A National Amenity Society

Parkwood Methodist Church, Parkwood Road, Longwood, Huddersfield, HD3 4TT. Application No. 2020/90480

Summary

Proposed Plans & Elevations

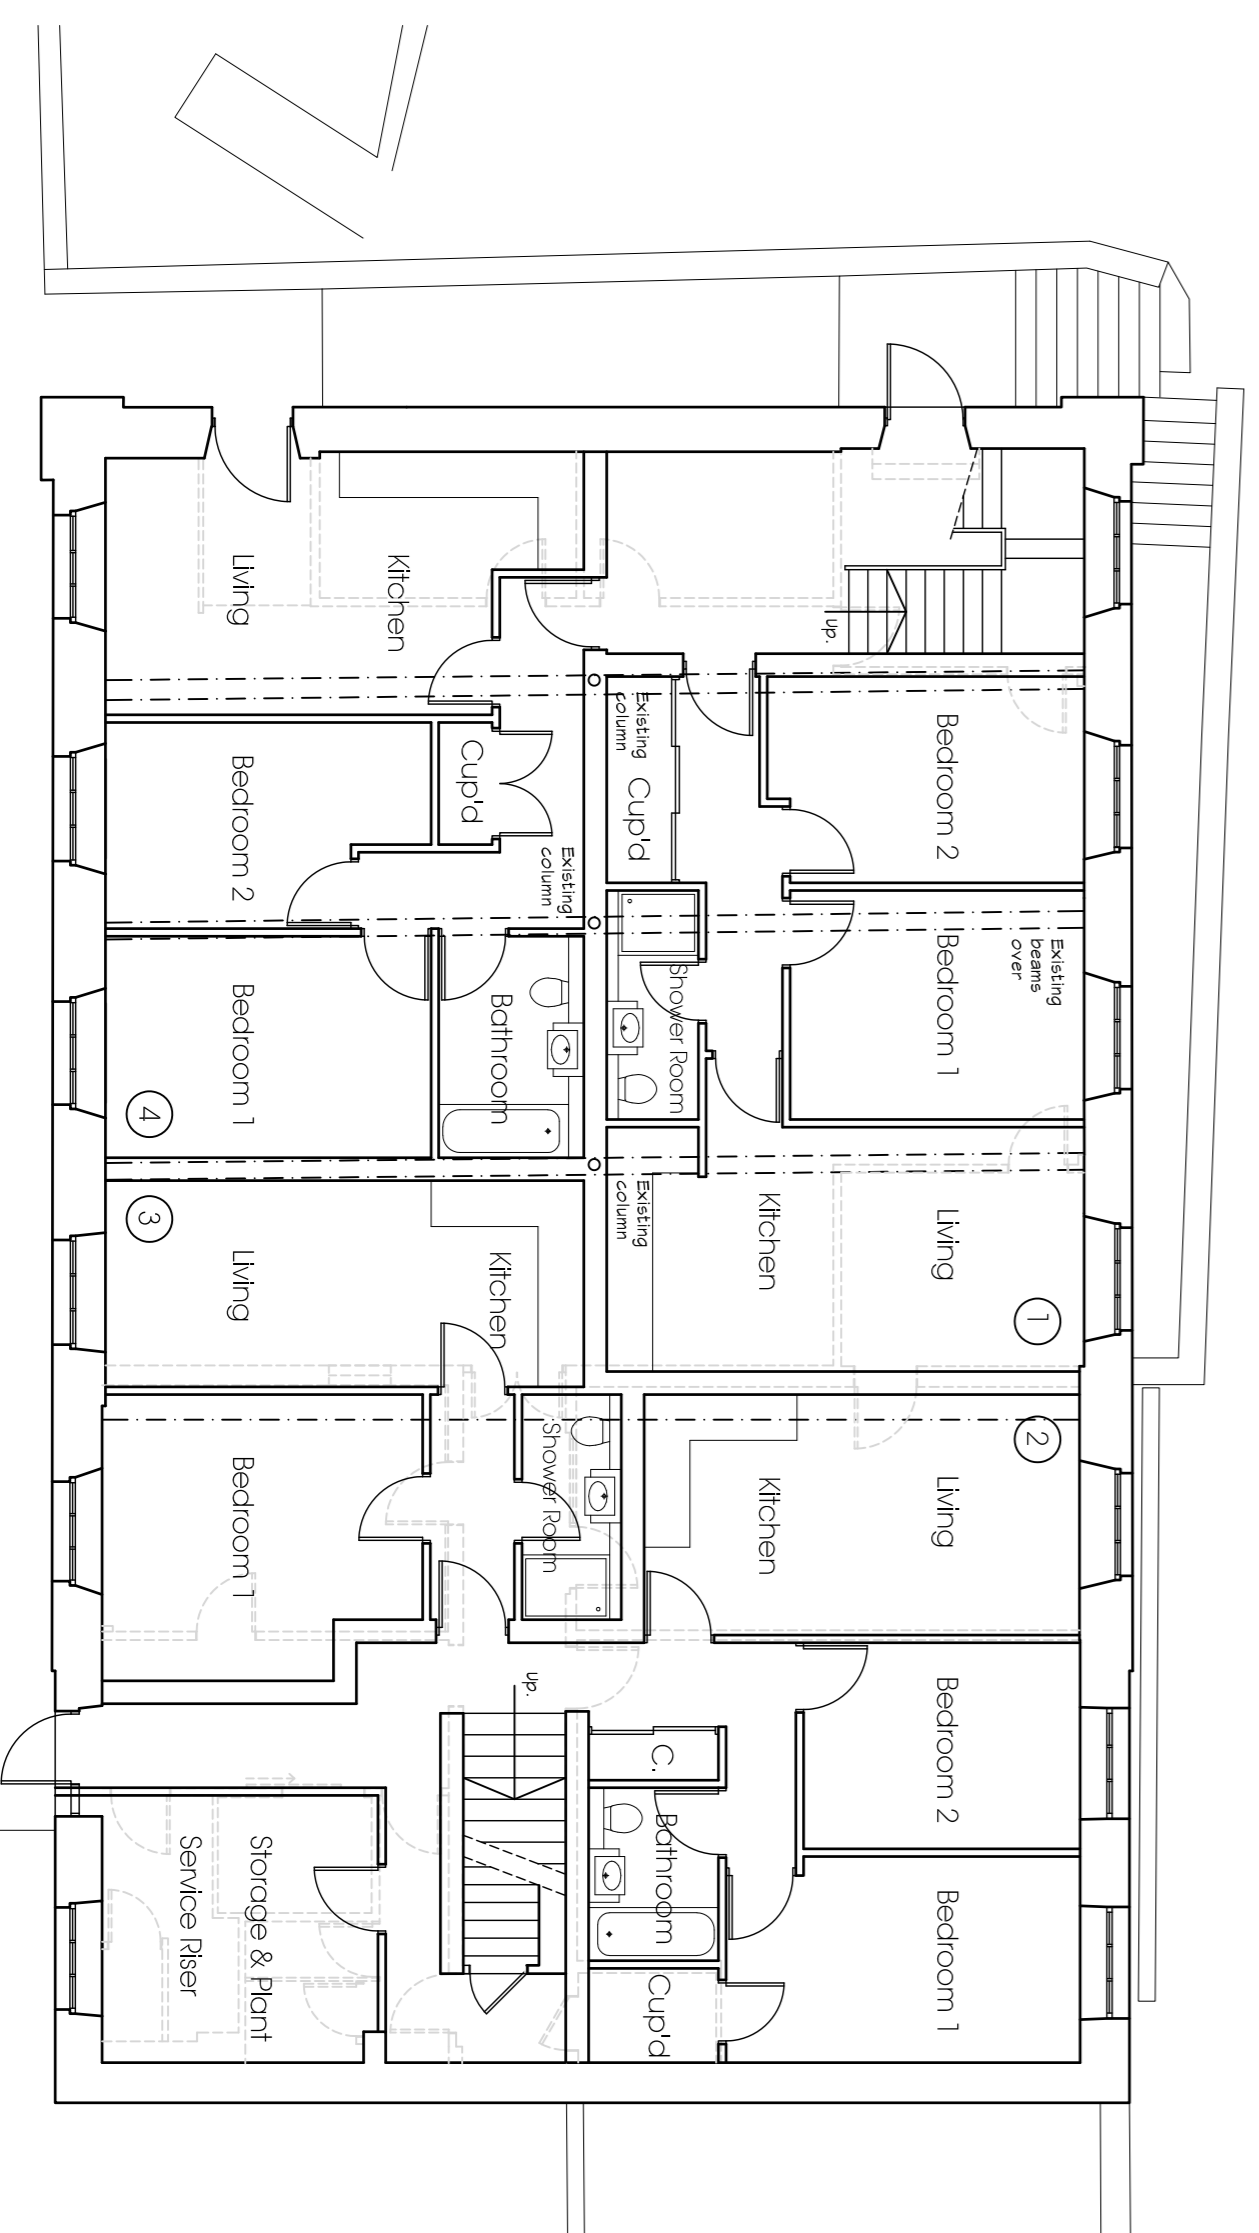
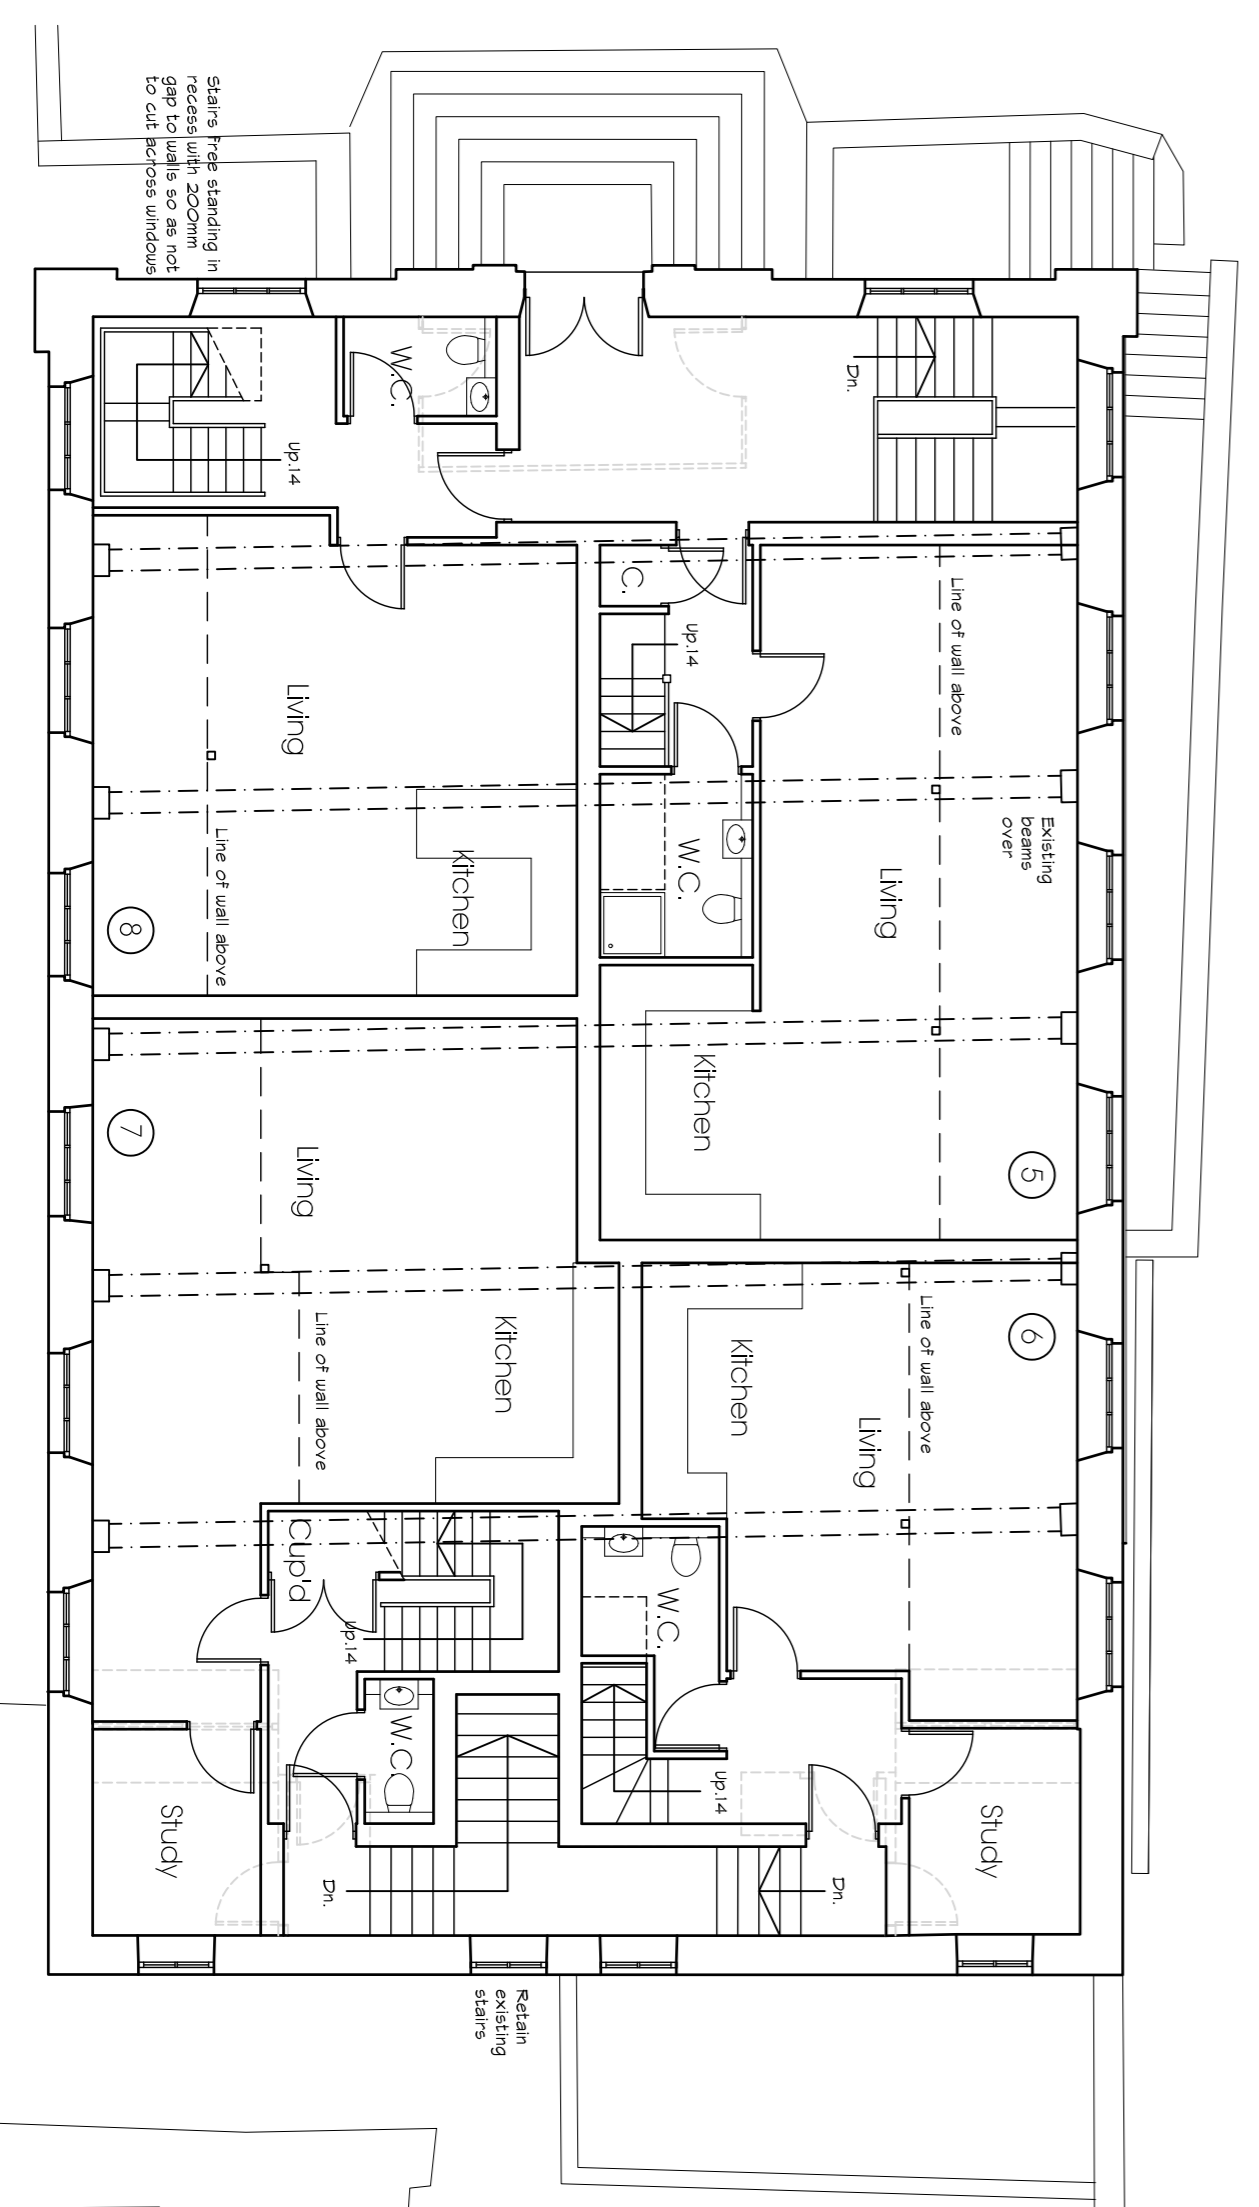
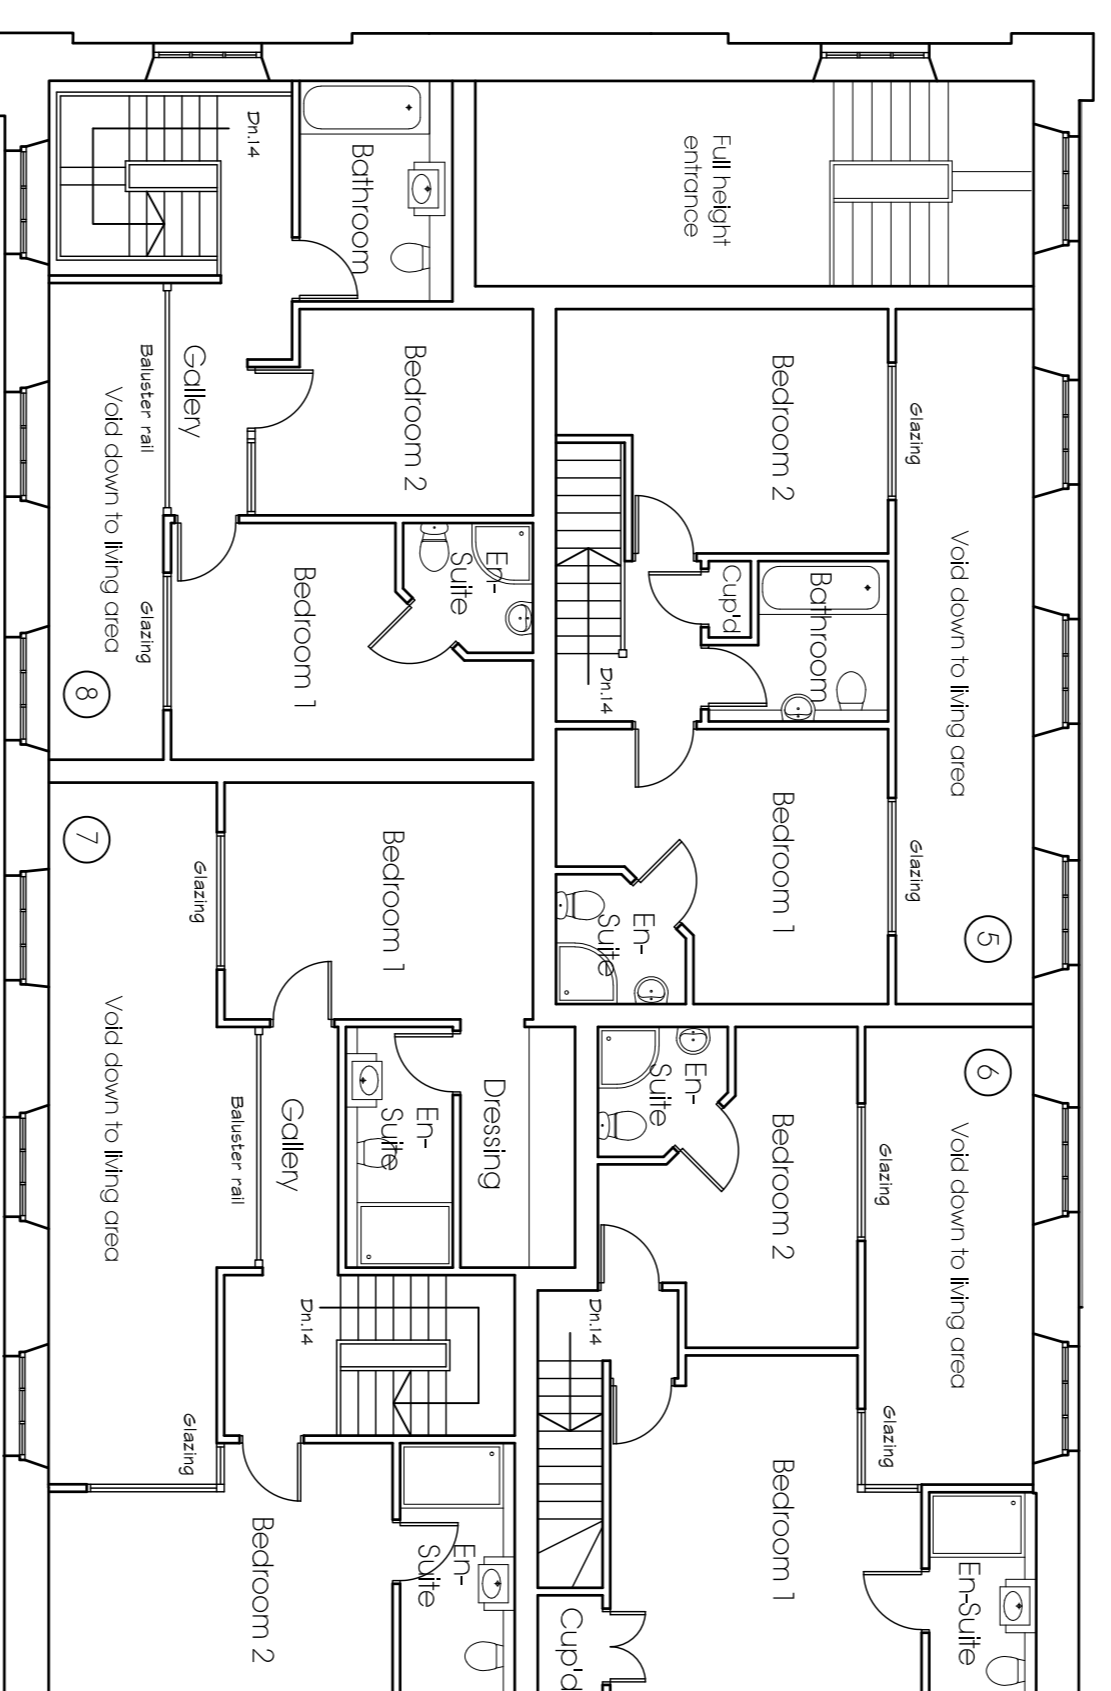
The CBA are concerned by the total loss of the intact 19th century interior of this Grade II Listed building that would result from these proposals, without any assessment of the significance of its different components. This is contrary to the requirements of paragraph 189 of the NPPF. There

appears to be no consideration within the associated documentation of ways in which the significance of the church's interior could be conserved through any scheme of adaptive reuse. The CBA consider this contrary to the requirements of paragraphs 190 and 193 of the NPPF. The scant justification for the harm to significance that would be caused by this scheme is the idea of sharing the responsibility for ongoing maintenance costs between more households. This does not equate to the 'clear and convincing justification required by paragraph 194 of the NPPF for the considerable level of harm. In its current form these proposals fall short of a great number of criteria for the conservation of designated heritage assets across local and national planning legislation and policy.

The proposed number of apartments would not only impact on the internal plan form of the building. The loss of lawns to the prominent east side of the building, in order to achieve adequate parking provision, also demonstrates that the proposed number of units represents an overdevelopment of the site. The impact on the external landscaping and setting means this scheme would harm the contribution that Parkwood Methodist Church makes to the character and appearance of the Longwood Edge Conservation Area. The CBA do not believe this level of harm to be justified.

The CBA agree that the optimum viable use for this site is likely to be a residential scheme, also that the size of the building will accommodate a degree of subdivision. However even the reduced number of 8 units, from the original 12, is still too many and does not constitute the optimal viable use for the site.

The CBA recommend that an assessment of significance should be required and used to inform a revised scheme, which should actively seek to minimise harm to the building's significance. An impact appraisal is also necessary to evidence how harm to the site's significance has been minimised and where unavoidable that harm is justified in order to secure the building's optimum viable use.

The CBA believe that a less intensive conversion scheme of fewer units could reduce the impact on the plan form and internal detailing, which are central to the significance of the building. A more imaginative scheme could retain more of the internal features and areas where the volume of the building could still be experienced. Fewer units would also have a reduced requirement for parking provision and therefore enable the highly visible lawns to the east of the church to be conserved for the benefit of future residents and the contribution this area makes to the character and appearance of the Conservation Area.
